## Application for a non-material amendment following a grant of planning permission. Town and Country Planning Act 1990

Conversion of existing garage into enlarged living, dining and kitchen space. Addition of 1/2 storey above to provide additional bedroom and en-suite accommodation. Associated internal and external alterations. Construction of detached timber framed garage.

21/00163/FUL

PROPOSED FIRST FLOOR & ROOF PLANS | SCALE 1:100 |

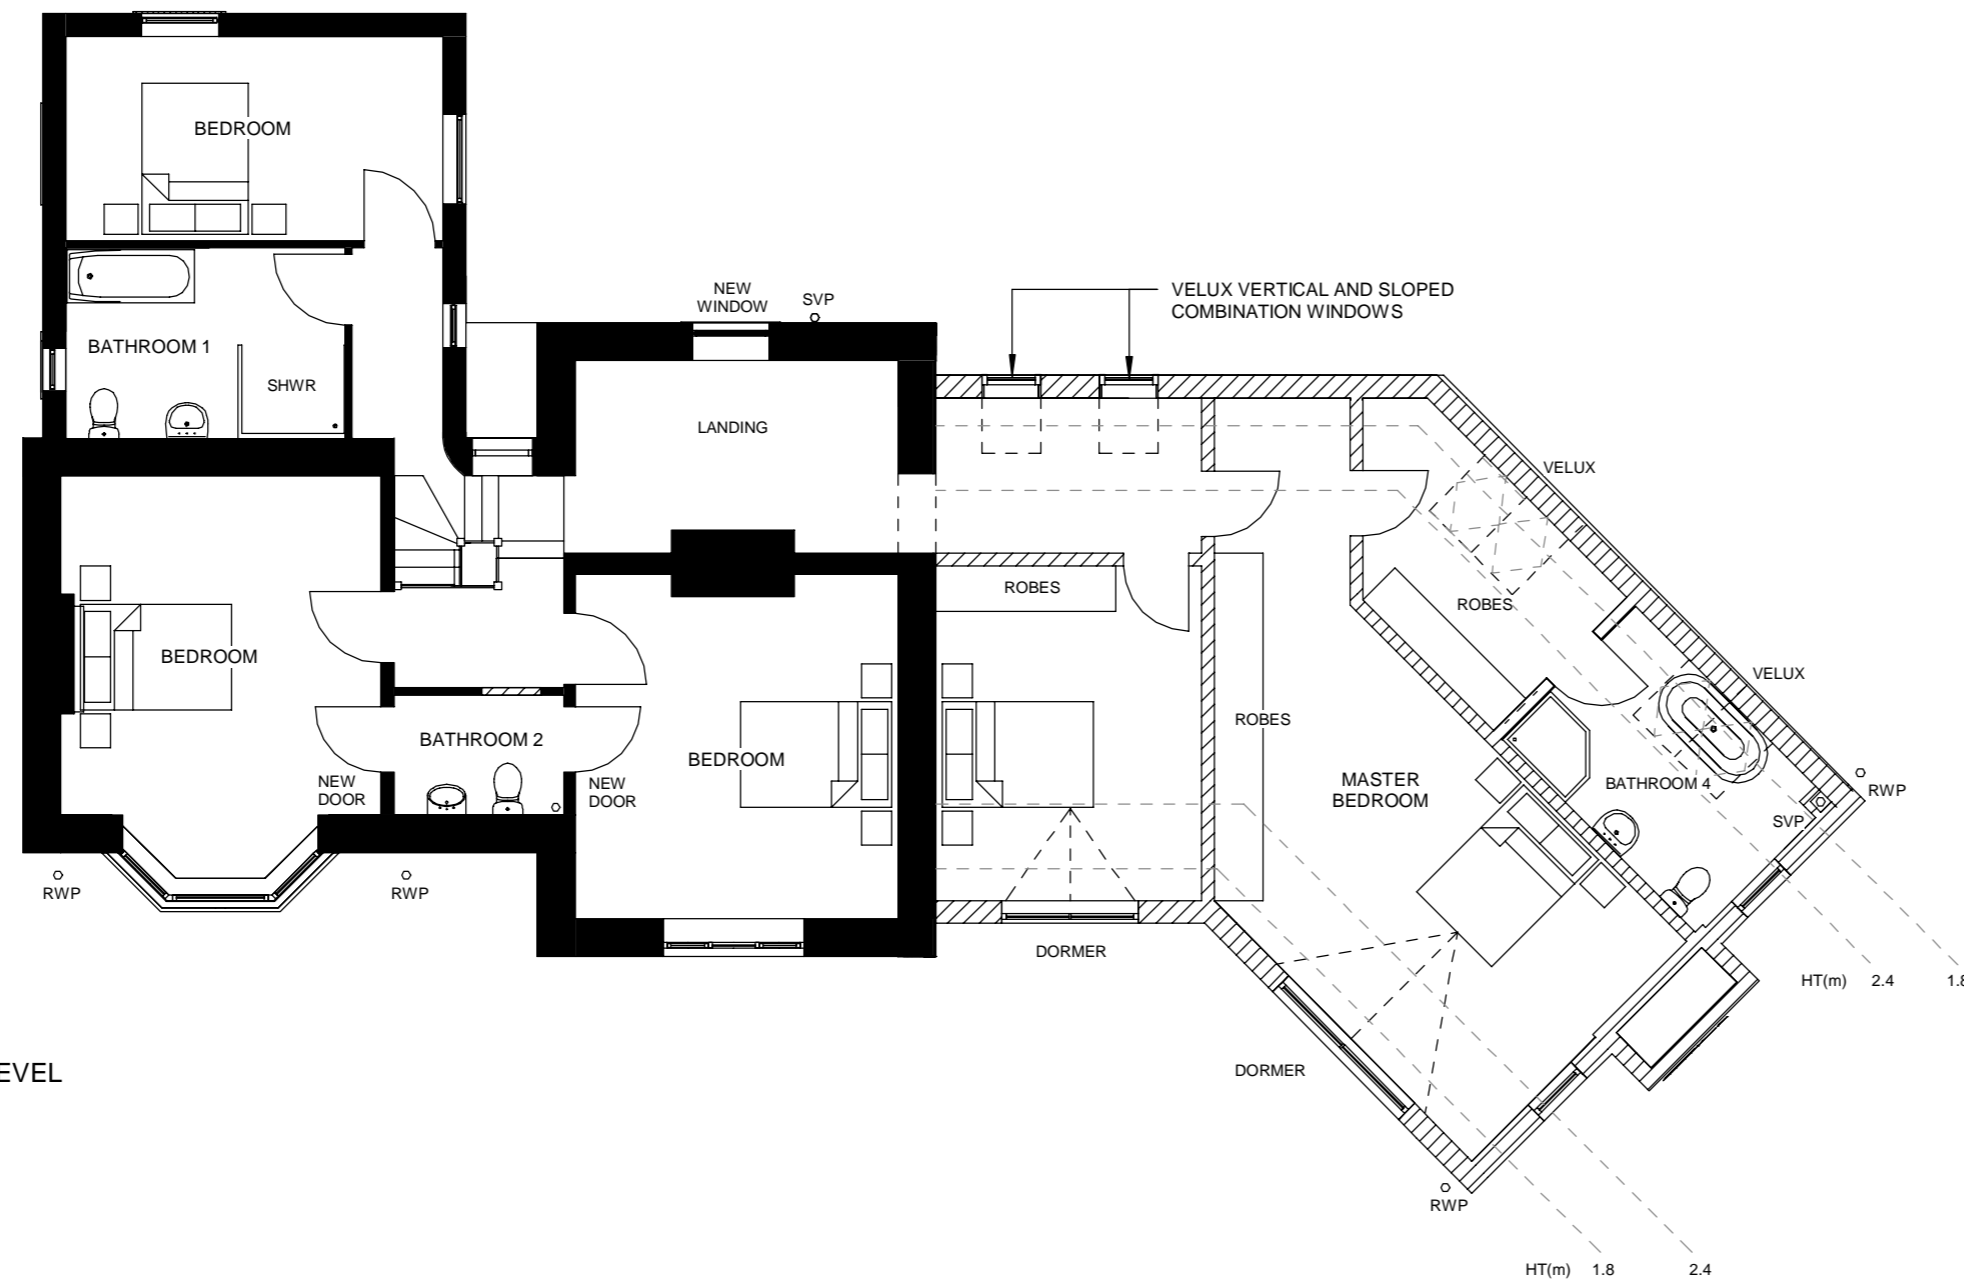
- House
- Off-White Render facing to the first floor, to match the existing – replacing proposed timber cladding.
  - Removal of 1no combination velux glazing to rear; removal of 4 no. rooflights to roof over landing.
  - Rear glazing expanse to family room replaced with 2no equal glazed openings.

- Light render to match the existing is proposed to the first floor, deviating from proposed timber cladding. We find this further allows the proposals to tie in with the existing, creates a continuity between the existing and proposed, and is easier for the client to source & maintain for construction.

PROPOSED SITE PLAN AND GARAGE ELEVATIONS

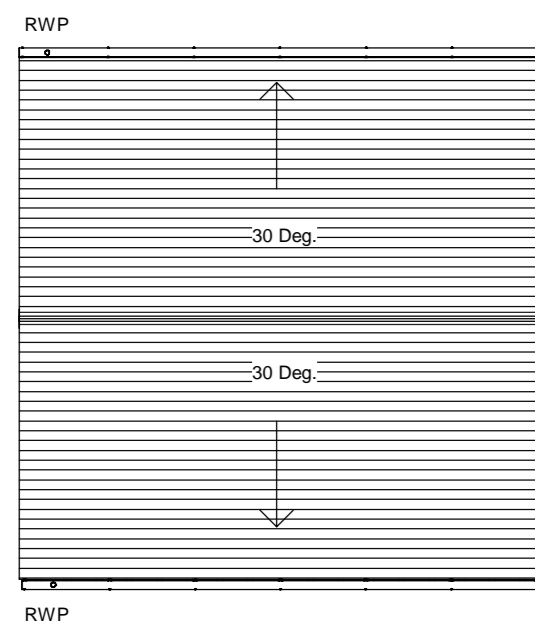
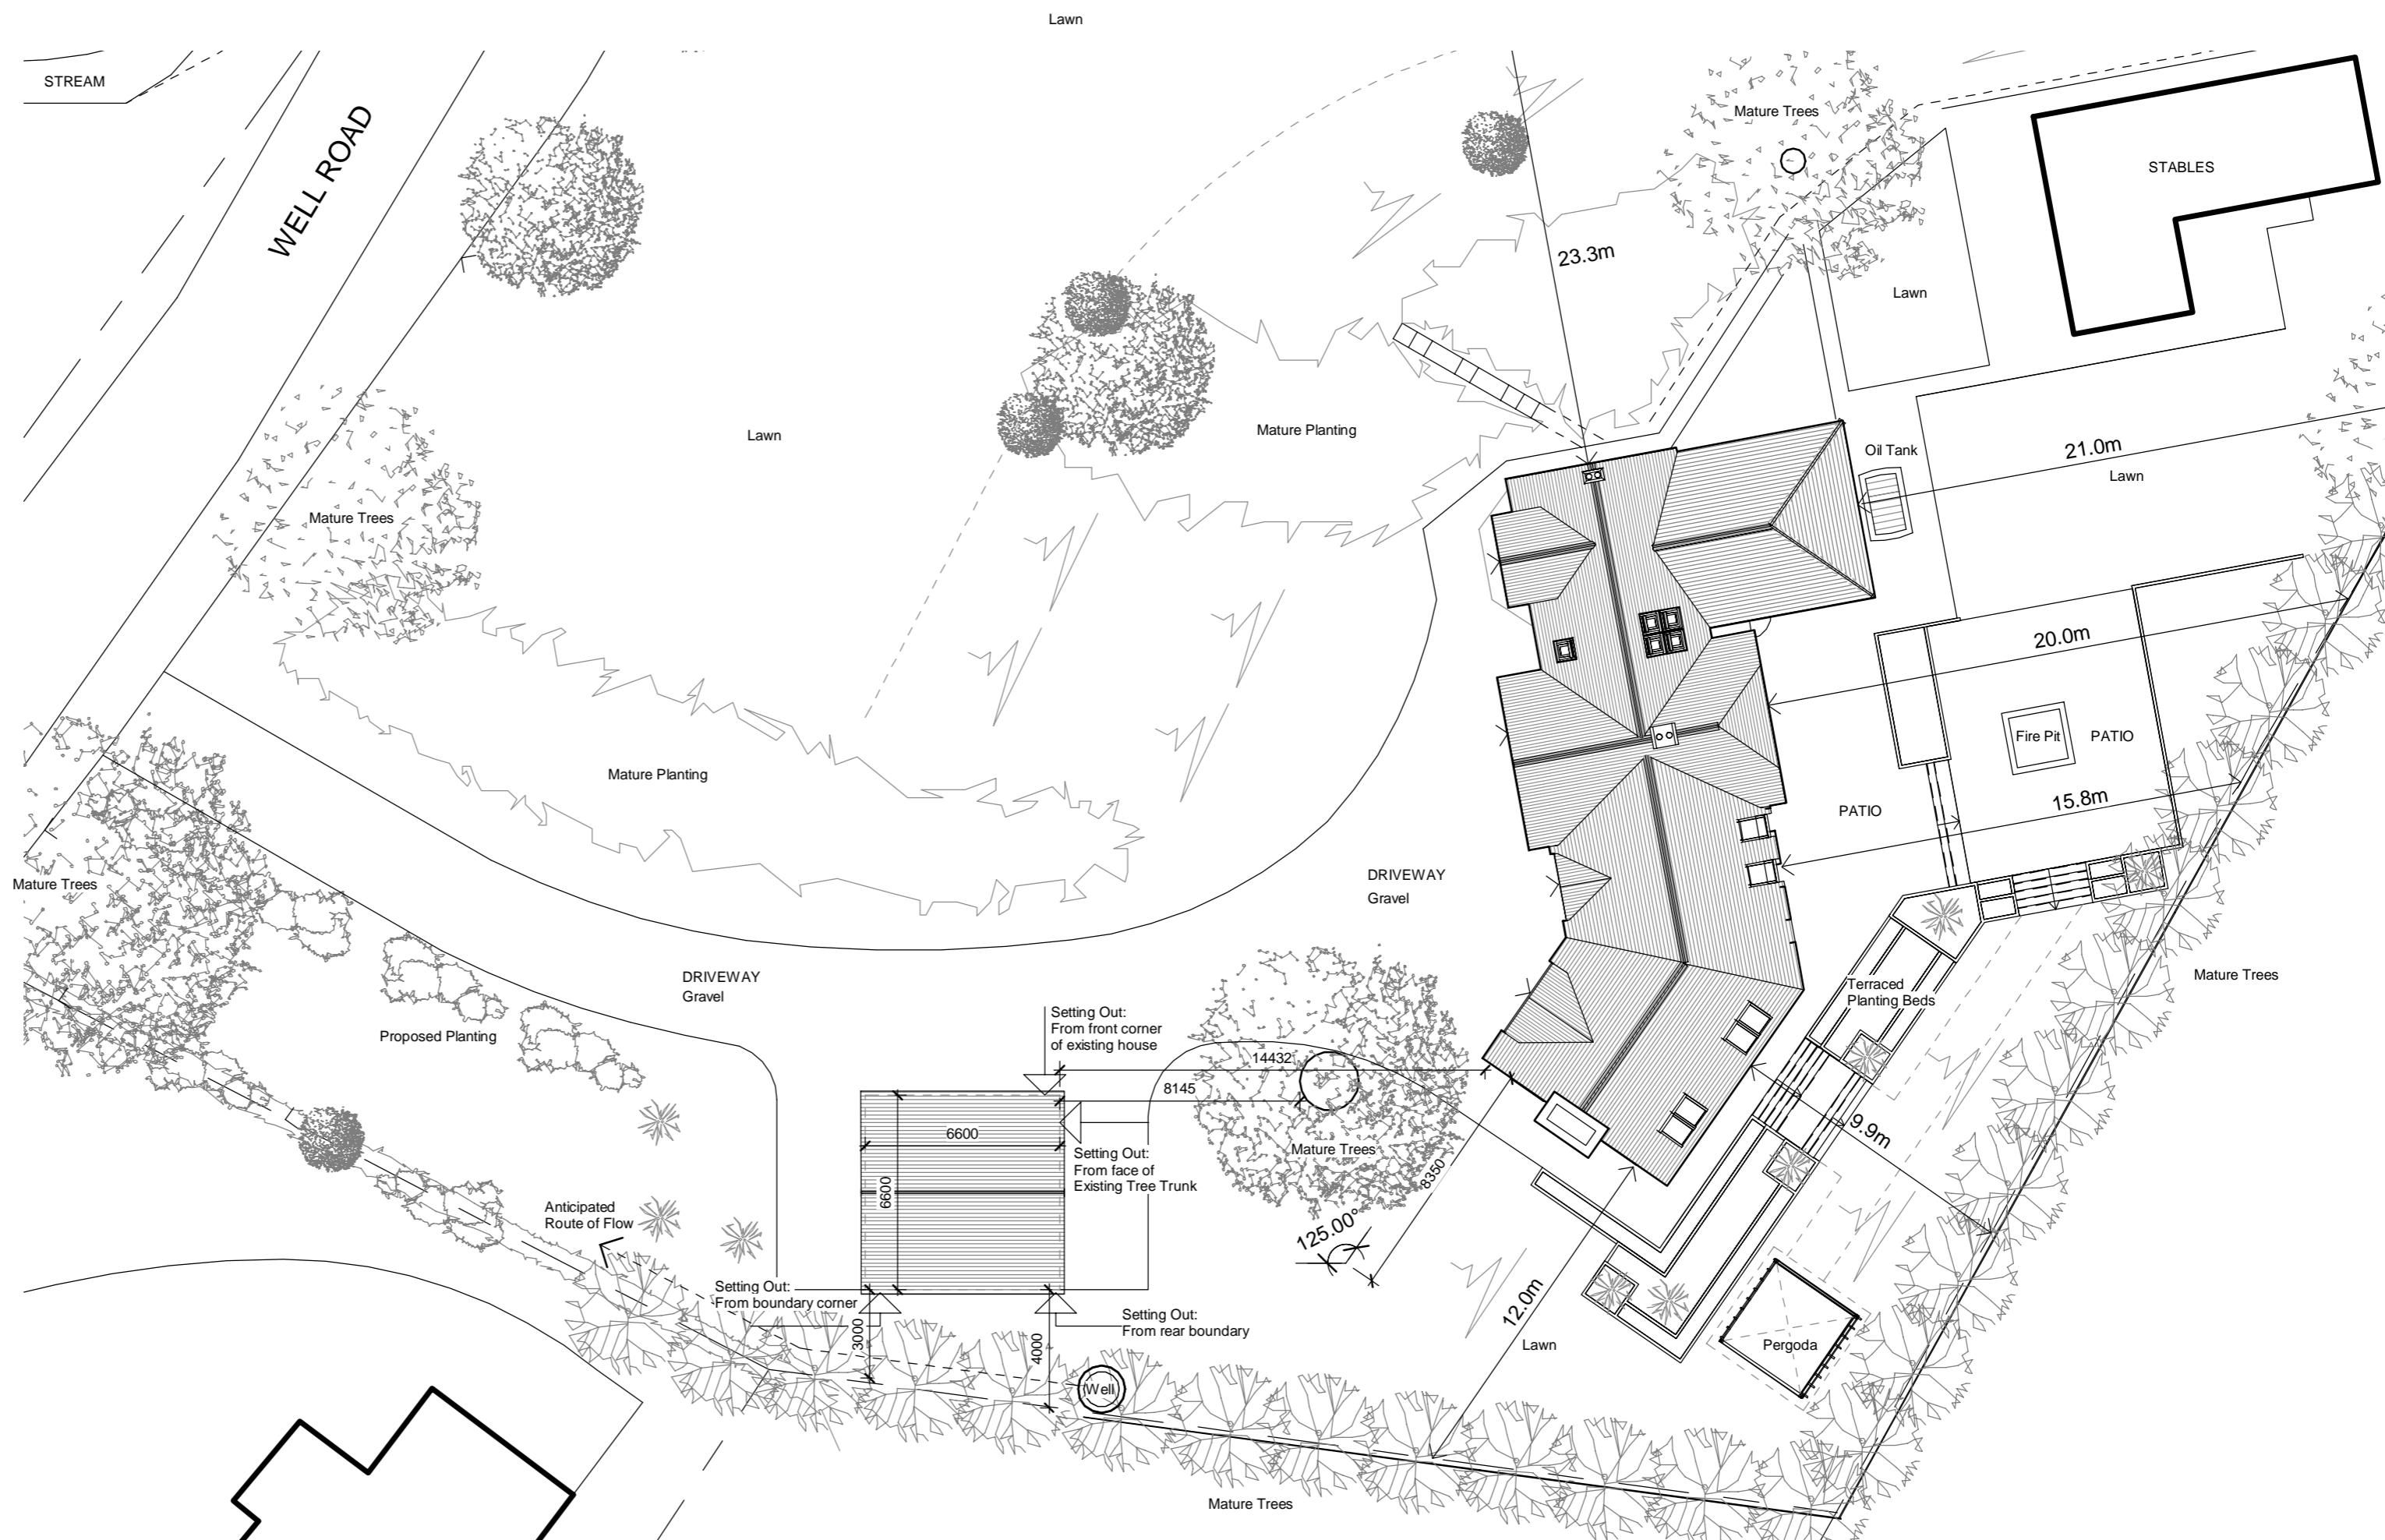
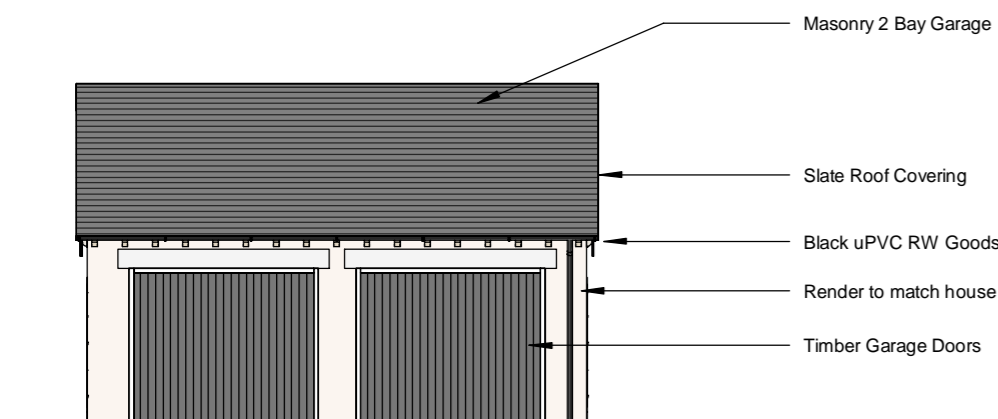
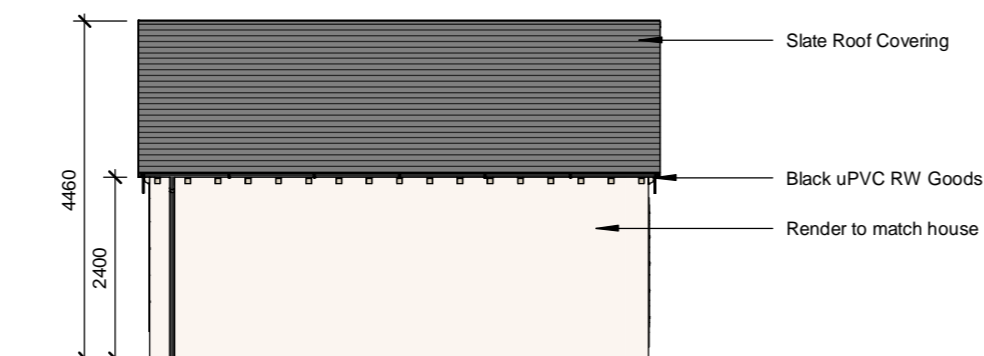
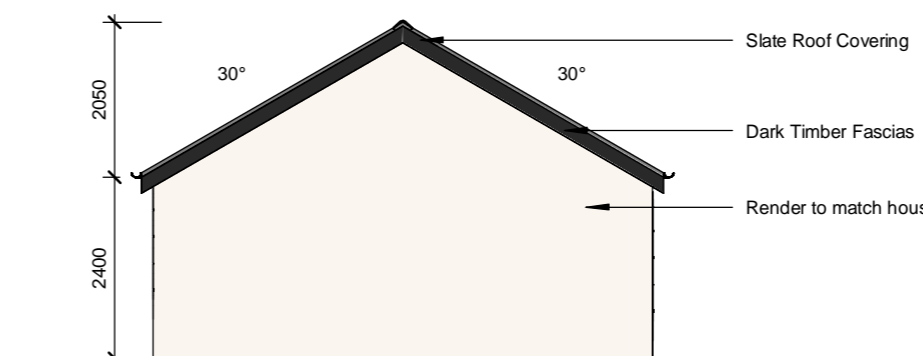
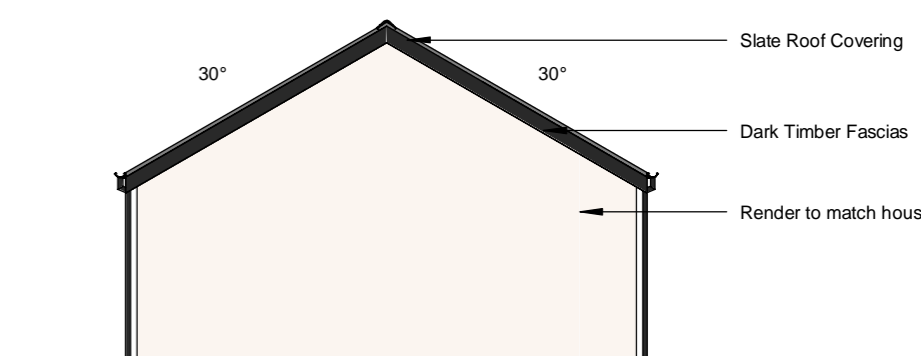
- Off-White Render facing to the garage walls, to match the existing – replacing proposed timber.

- Render is also proposed to the garage, in place of stone, again creating continuity between the main house and garage, whilst allowing the garage to remain subservient to the main property. This is also more efficient to source and construct than the proposed stone.
